Parcel 24351
DTQ:MC

26 May 2017

PROPERTY: LOT 12 DP 1159243, 170 MYALL STREET, DUBBO
YOUR REF: SSD 7720 - DUBBO HOSPITAL REDEVELOPMENT - STAGE 4

DRAWING TITLE:  
SITE PLAN  
SITE PLAN - STAGE 4, GROUND AND LEVEL  
1

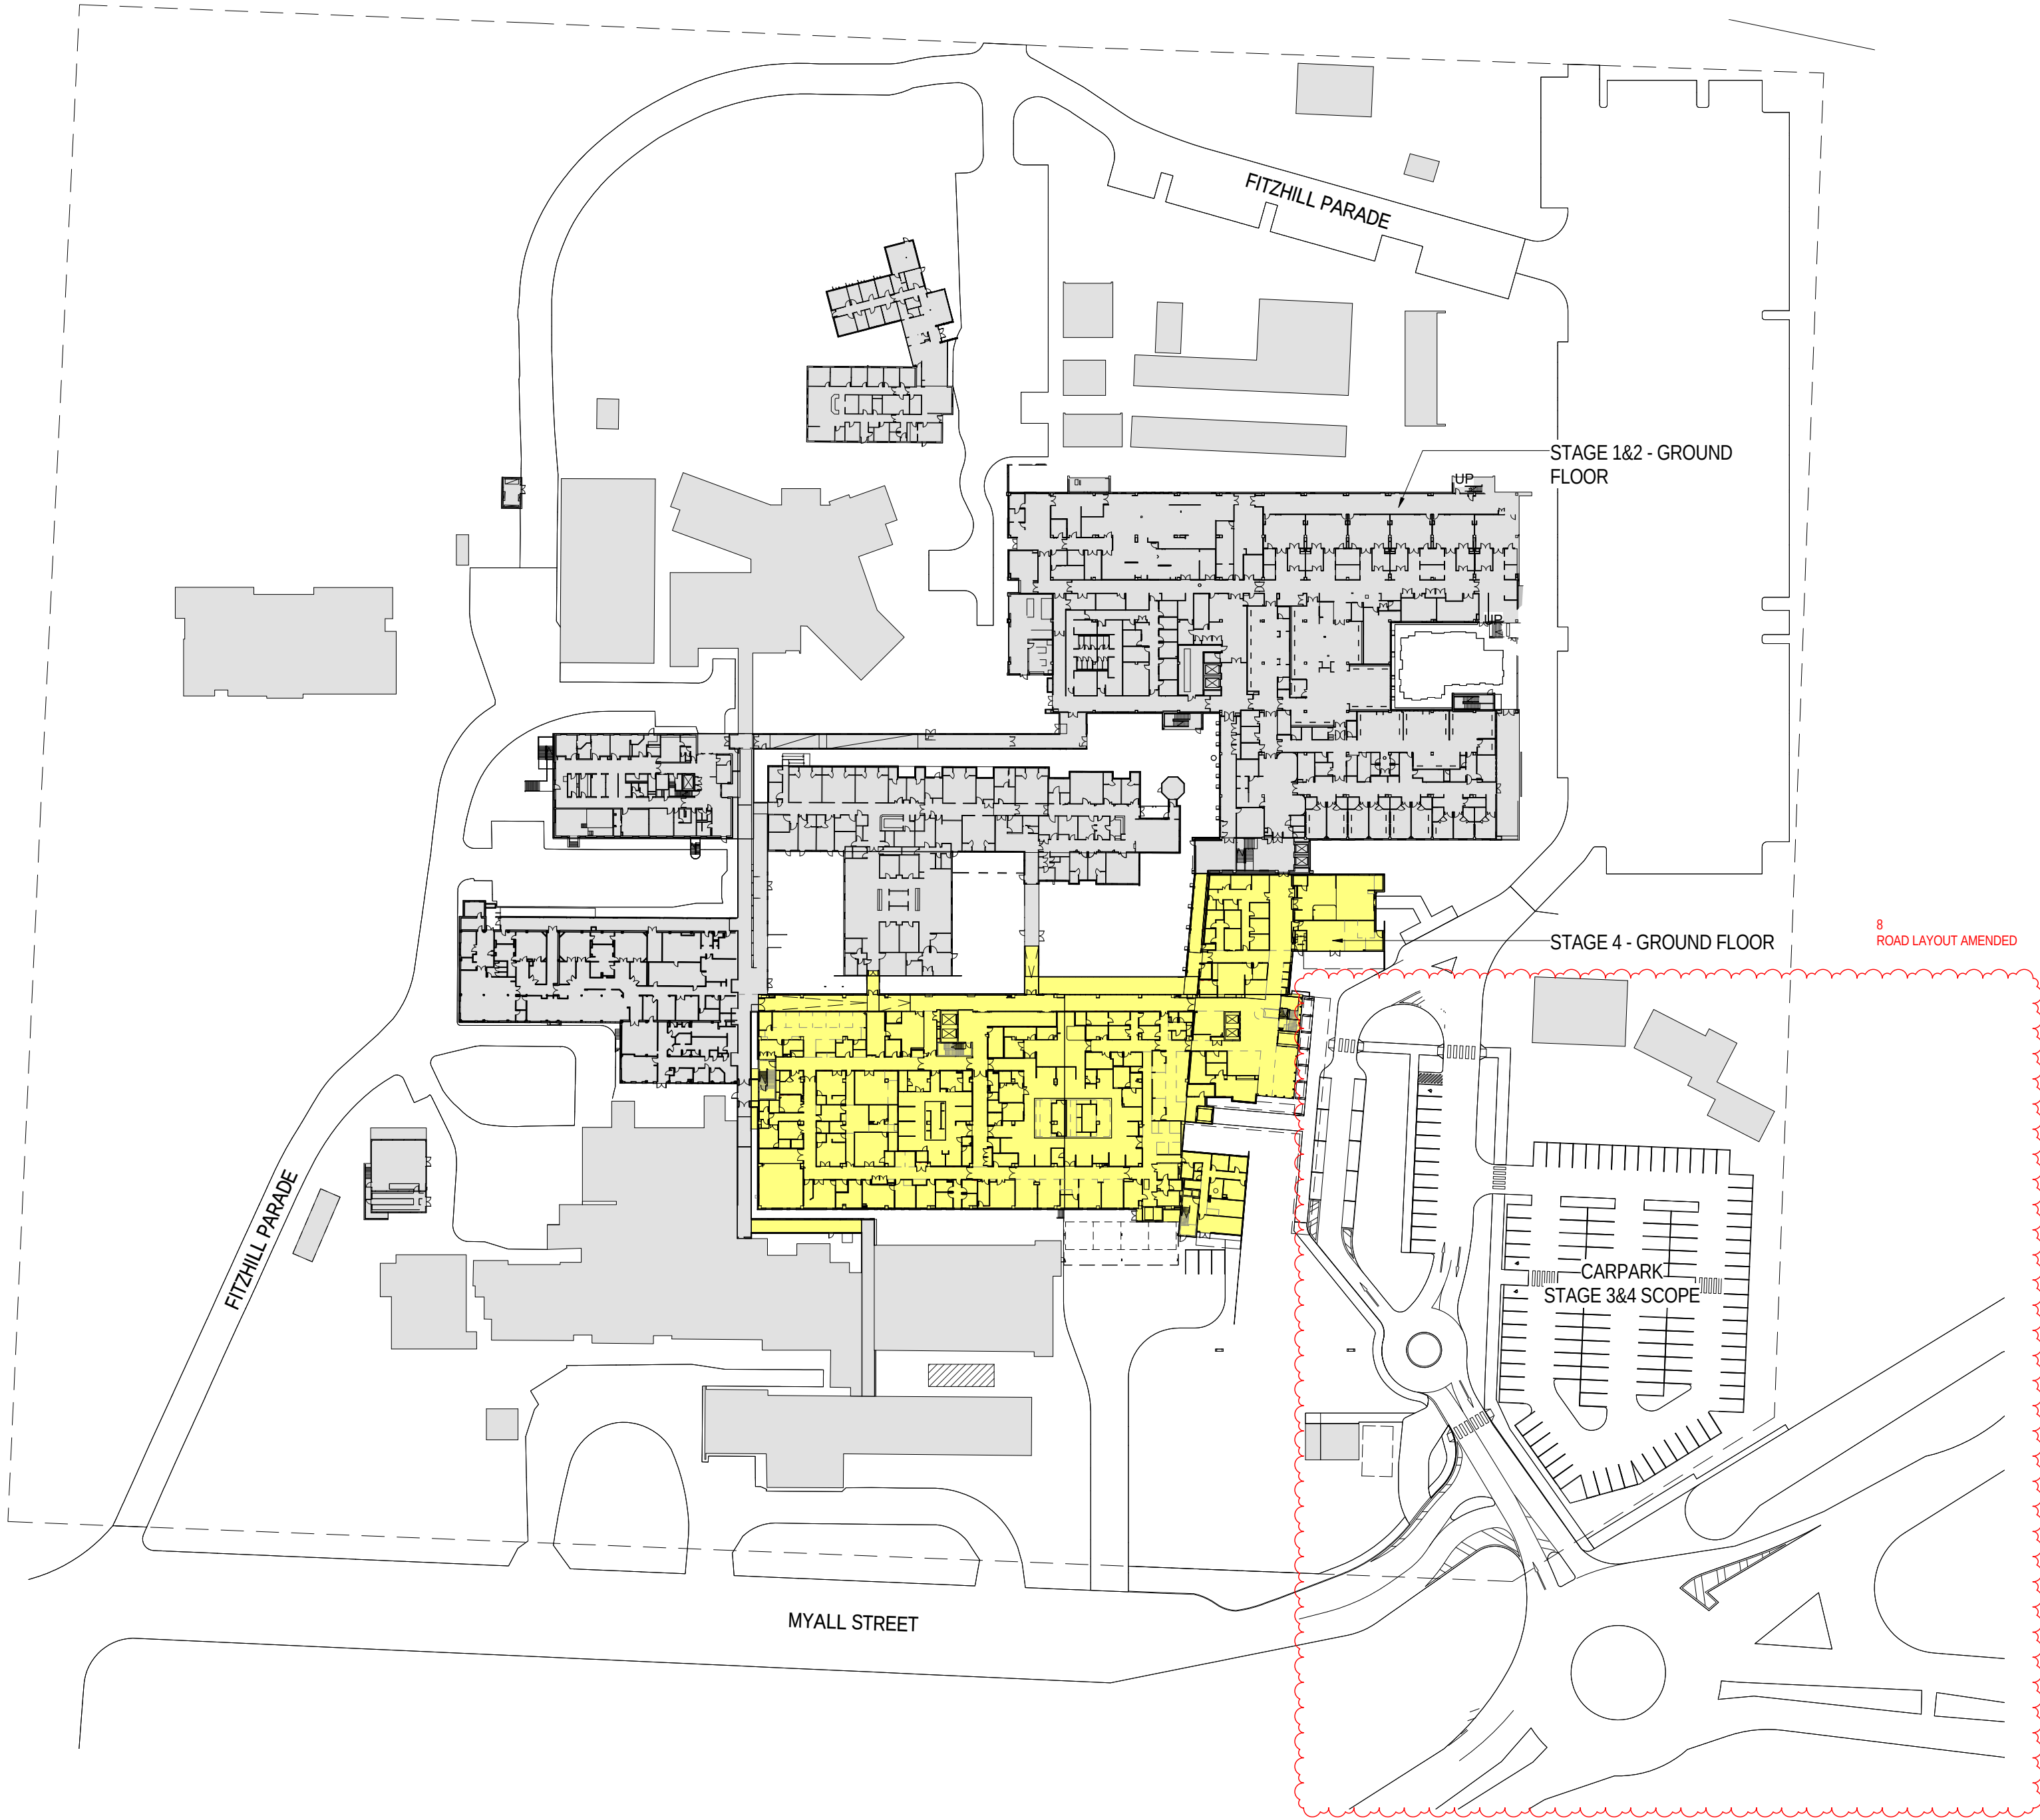
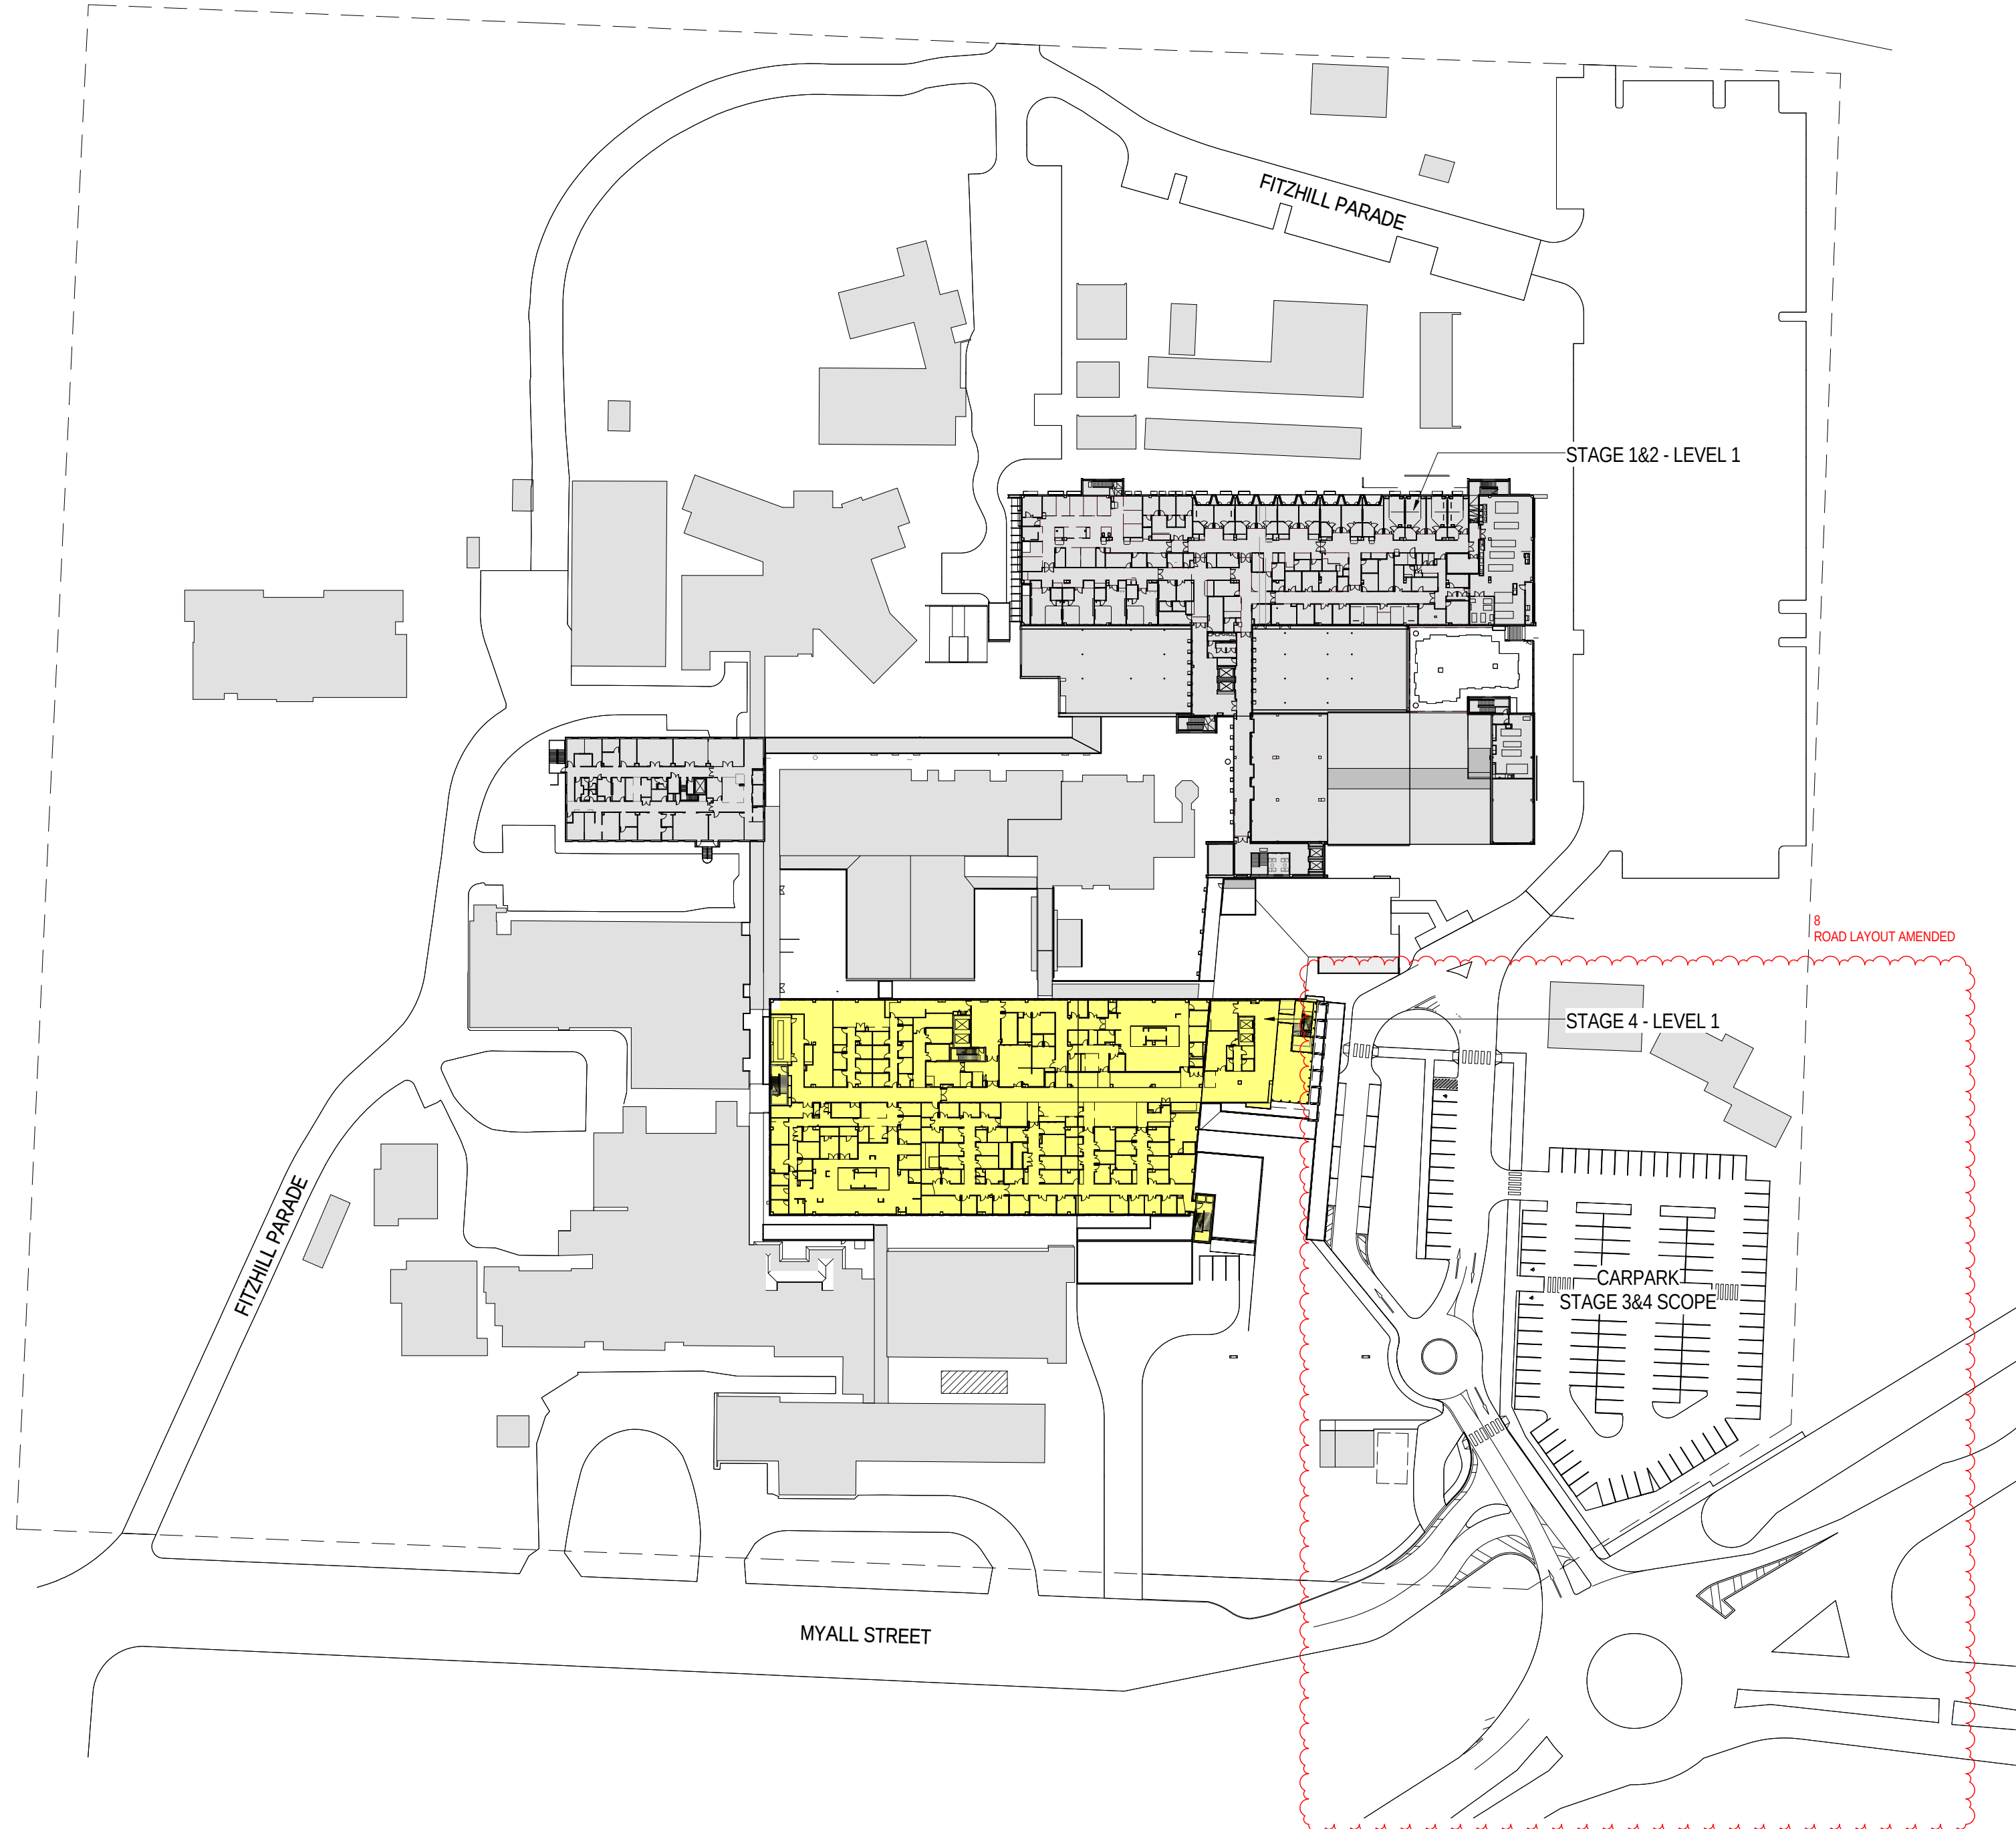
- In relation to traffic arrangements for Stage 4 (SSD 7720), the proposed access arrangements identified in the GTA consultants 'Dubbo Health Service Redevelopment Stages 3 and 4, State Significant Development, Transport Assessment' dated 22/02/17 and in particular Drawing No.16S1359000-02-01-P6, Sheet 01 of 07, identifying proposed access re-arrangements off Myall Street and off the Cobbora Road roundabout are unacceptable to Council.

4. The proposed traffic management comprising of the Myall Street realignment, McGuinn Drive intersection and new Cobbora Road access and transition appears to promote an environment for traffic and pedestrian conflict with constrained turning paths, short travel distances for driver interpretation and decision making, no vehicle separation into Myall Street.

DRAWING TITLE:  
**SITE PLAN  
CARPARKING PLAN**

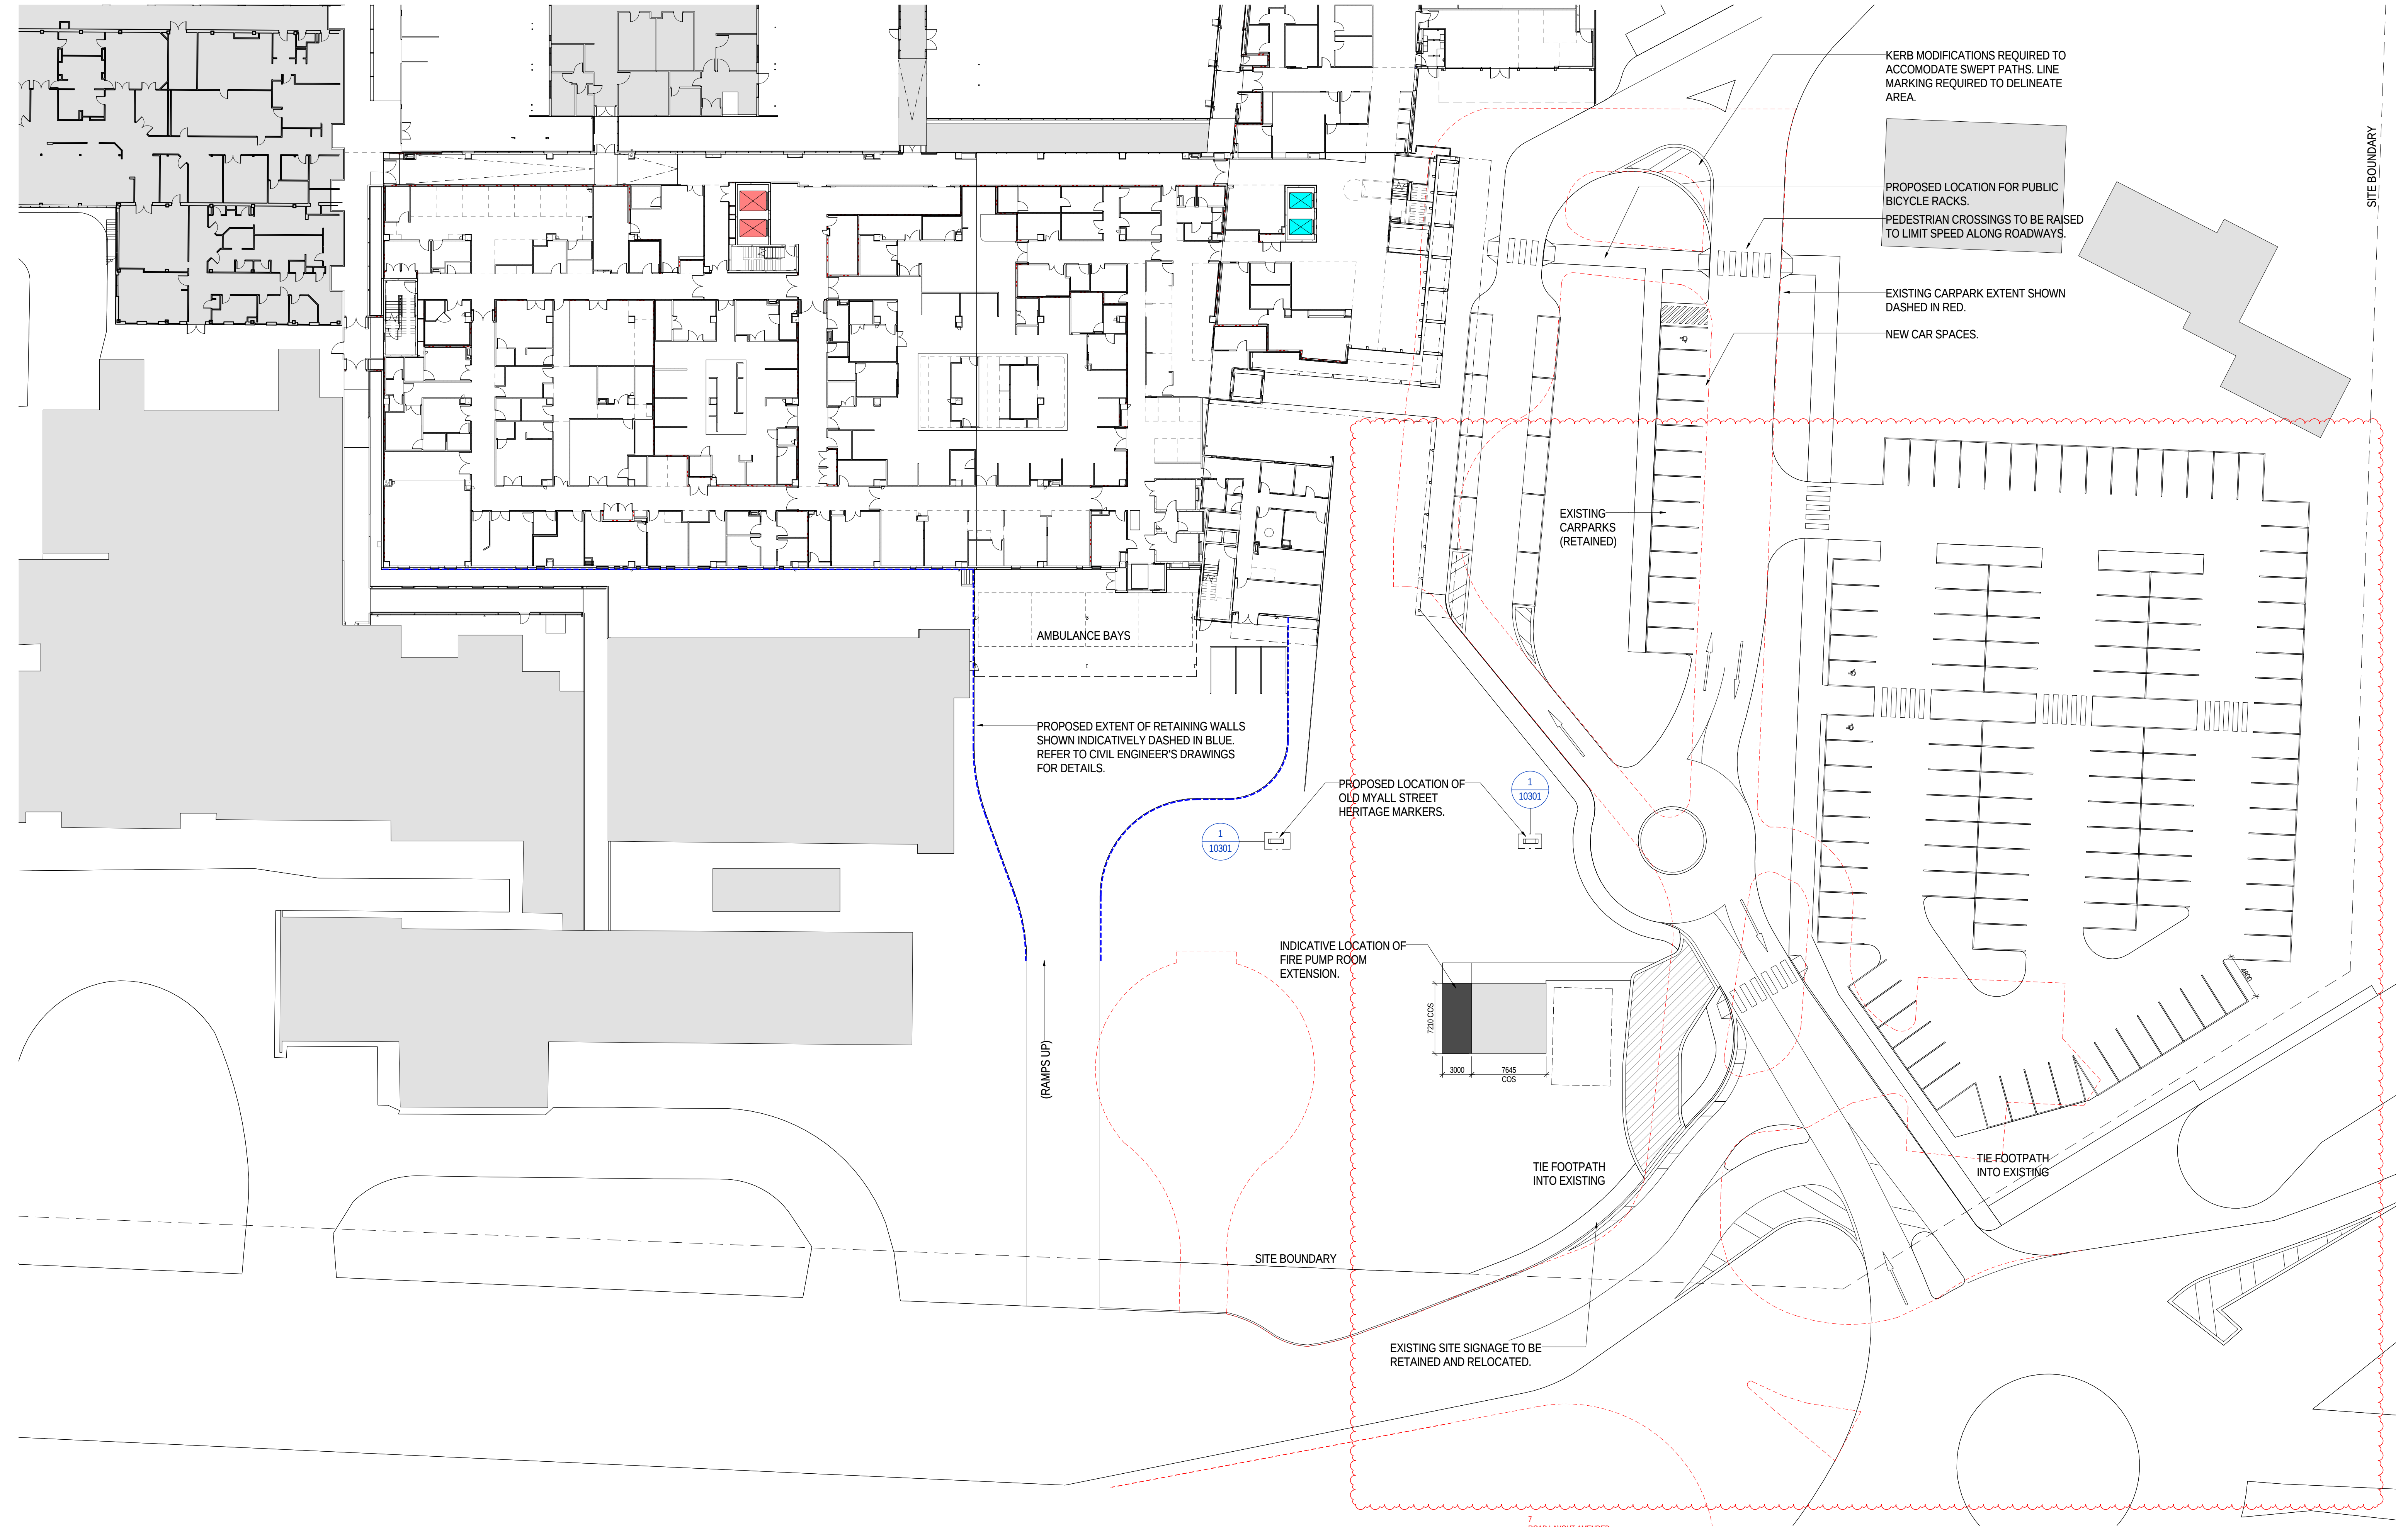
5. There are other service plans showing a proposed car parking area off Myall Street on the eastern side of the new Emergency Department but there is no reference to this car park in the Transportation Assessment. If this progresses then the traffic generation needs to be included in the assessment.
